Subject: Y/10/26/PL Rookery Farm

Following our call, I have looked into the query regarding amendments to the red line boundary after an application has been validated. I can confirm that we do not accept changes at that stage because of the impact this has on re-advertisement of the application. Further details about this can be found within our Customer Advice Note published here: <https://www.arun.gov.uk/planning-applications-customer-advice-note/>

2601_200_PL0
*** PROPOSED DRAWINGS**

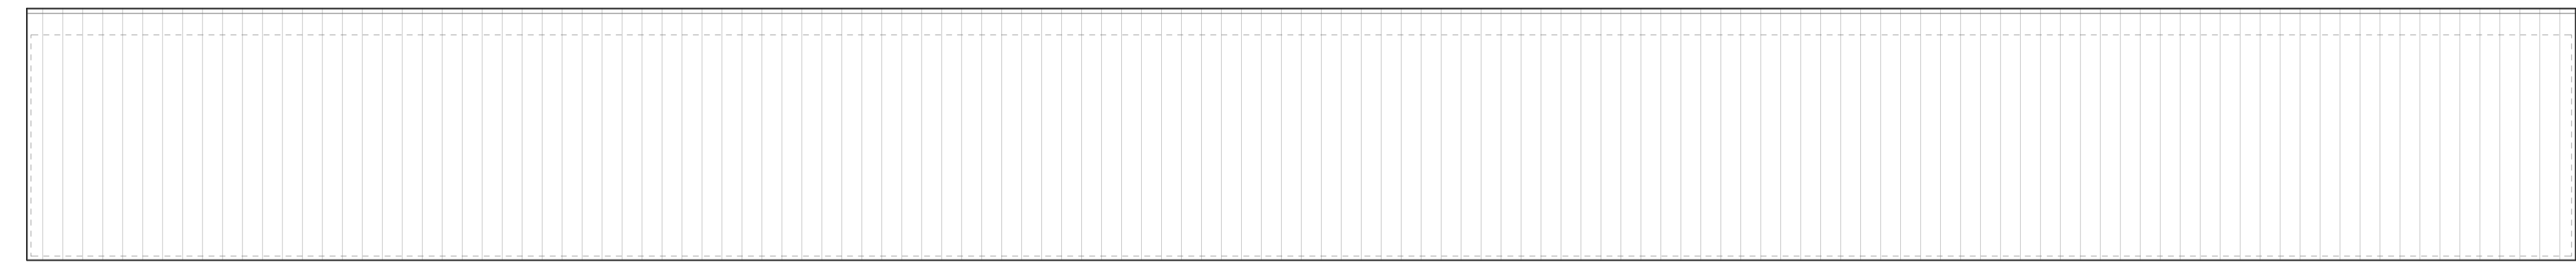
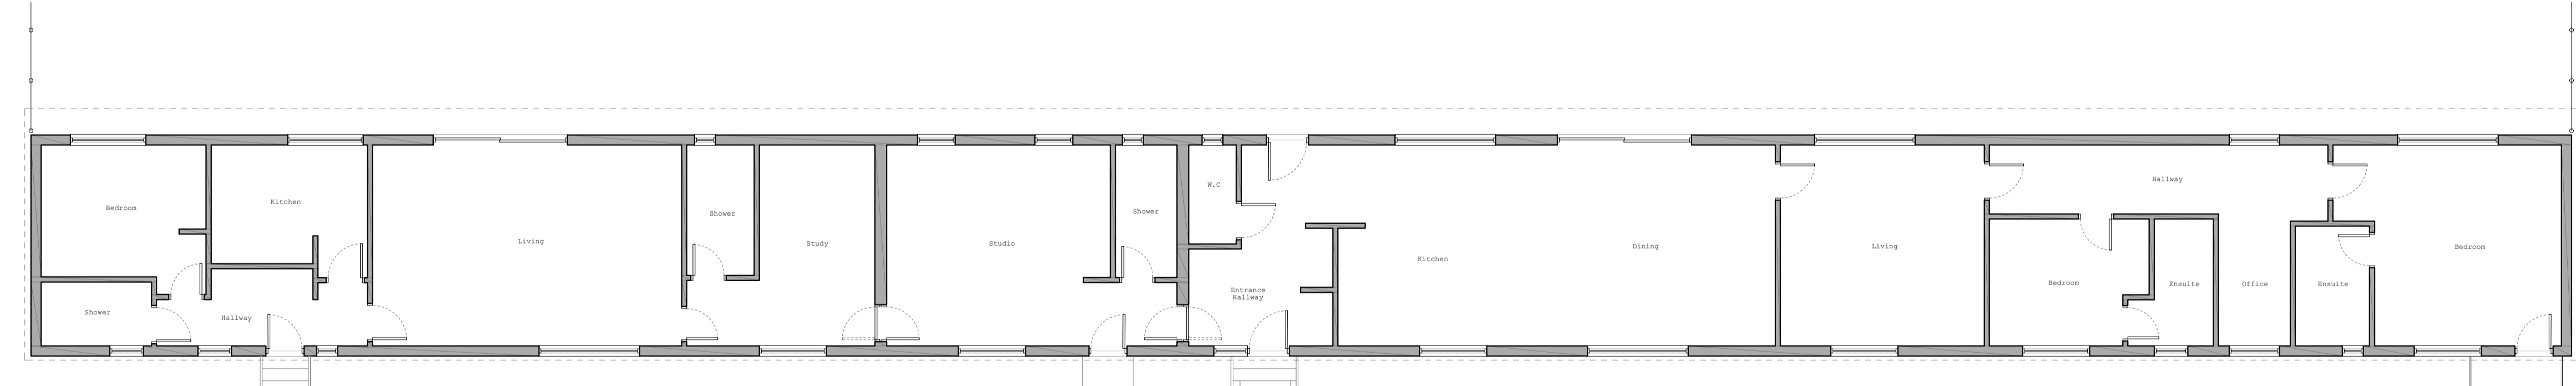
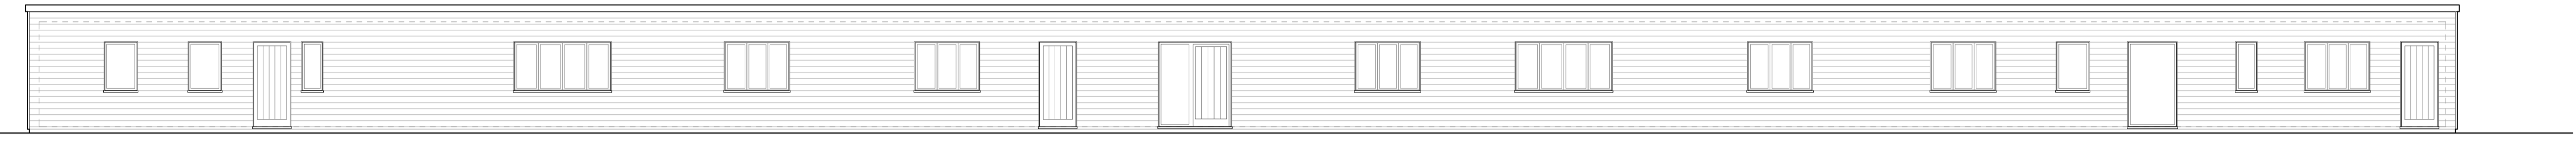
With regard to the number of dwellings on the site, I consider it evident that; despite the interconnectivity, the building has been designed to function as up to three separate dwellings. Evidence observed on site, including the number of front doors, subdivision of the land, and the number of ASHP units, has informed this view. I have also been provided with a Building Control report which confirms that the structure was designed as three separate dwellings for the purposes of fire-spread regulations.

Finally, I noted during my visit that construction of a pergola has commenced at the rear of the property. Given the scale of this structure, I would recommend including it within the submitted plans.
